Portishead Branch Line (MetroWest Phase 1)

TR040011

**Response to the Planning Inspectorate's letter of advice under s 51 of the Planning Act 2008 and dated 24 January 2020
Planning Act 2008**

Date: March 2020

2.41 - Easton-in-Gordano Flood Mitigation Plan

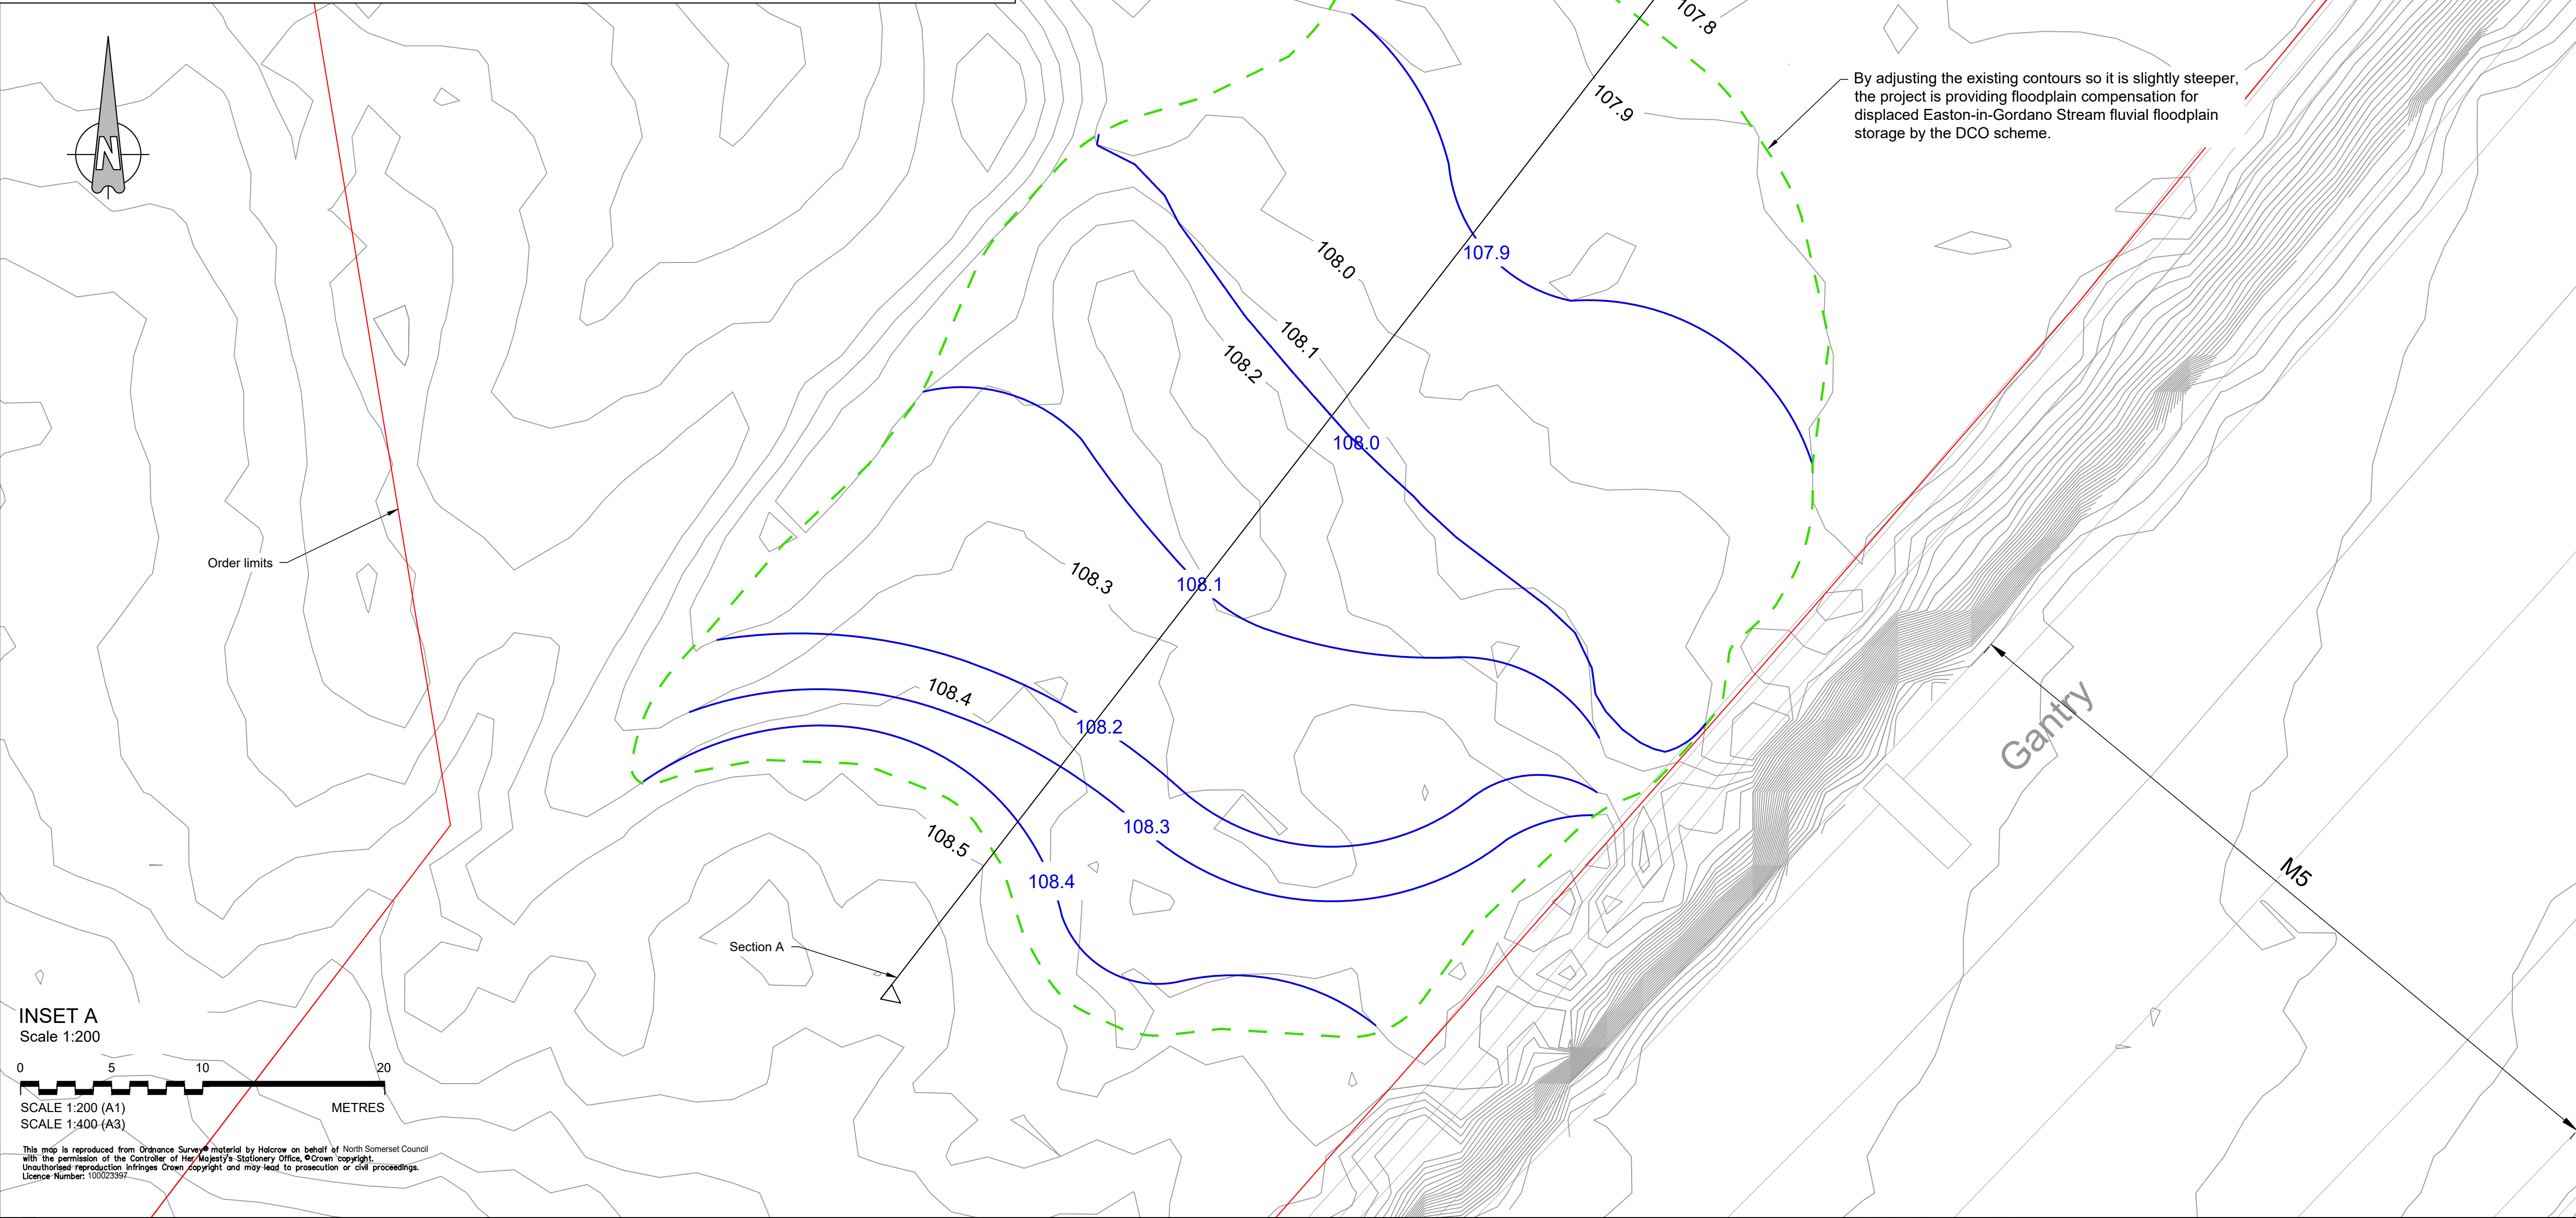
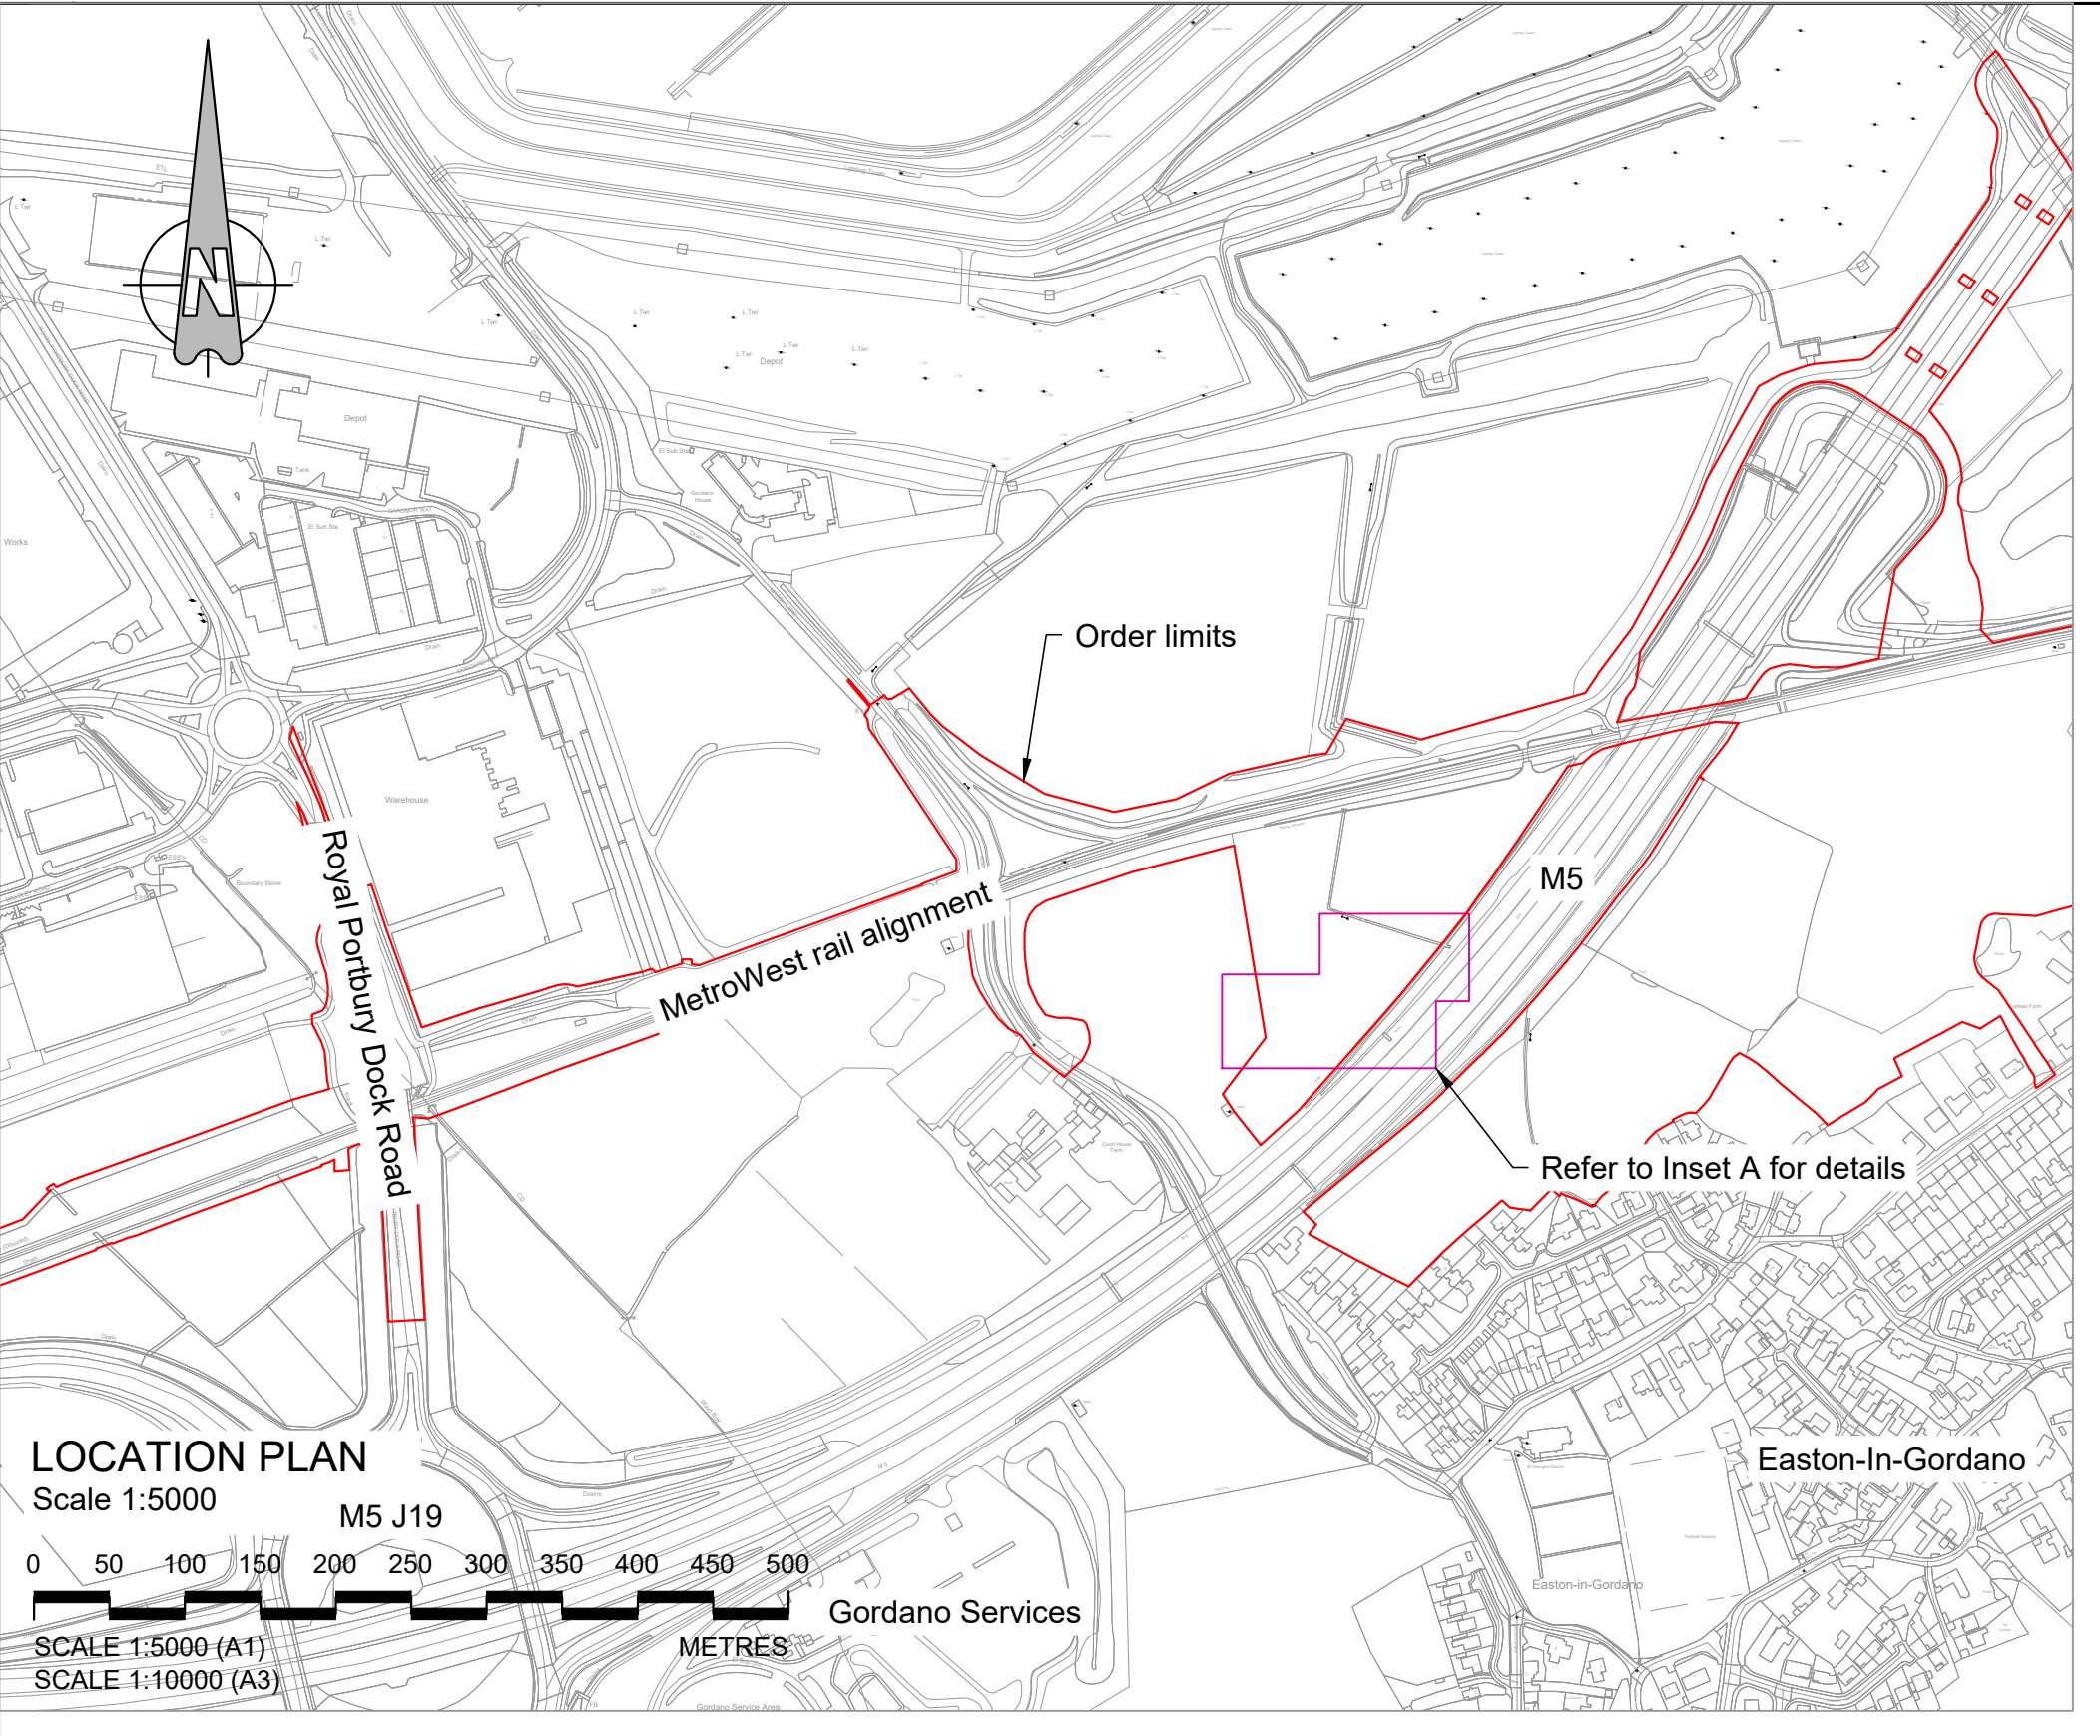
<p>The Applicant also proposes to increase the footprint of the railway embankment within the Easton-in-Gordano Stream floodplain which would result in displacement of potential floodplain storage, south of the railway. The Applicant therefore proposes floodplain storage compensation. In preparation for the examination the Inspectorate seeks to understand the extent to which the application of the revised climate change allowances may (or may not) affect the findings in this regard. In particular whether such detail would result in a need for increased levels of flood compensation to address greater levels of floodplain storage being displaced.</p>	<p>Section E</p> <p>The December 2019 NPPF Guidance on climate change guidance specifies for small catchments such as the Easton-in-Gordano Stream catchment (<5km²) rainfall climate change allowances should be applied rather than river flow allowances. Assessment of the central and upper end rainfall allowances is required (20% and 40% respectively for both the 2075 and 2115 simulated future years). As mentioned above, the MetroWest Phase 1 FRA modelling of Easton-in-Gordano Stream applies a 20% climate change allowance for 2075 and 30% allowance for 2115.</p> <p>We have now undertaken simulations applying the December 2019 NPPF Guidance upper end climate change allowance (applying 40% uplift for both the 2075 and 2115 simulated future years). Results of these simulations show that the proposed floodplain storage compensation within the Easton-in-Gordano Stream floodplain does provide mitigation when applying the current upper end climate change allowance of 40%.</p> <p>The proposed floodplain storage compensation provides compensation for fluvial flood events up to a peak level of 8.3mAOD. The simulated 100 year return period fluvial flood peak level with 40% climate change allowance is 8.28 mAOD in 2075 and 8.29 mAOD in 2115 i.e. no additional floodplain compensation is required beyond what is proposed in the DCO application.</p>
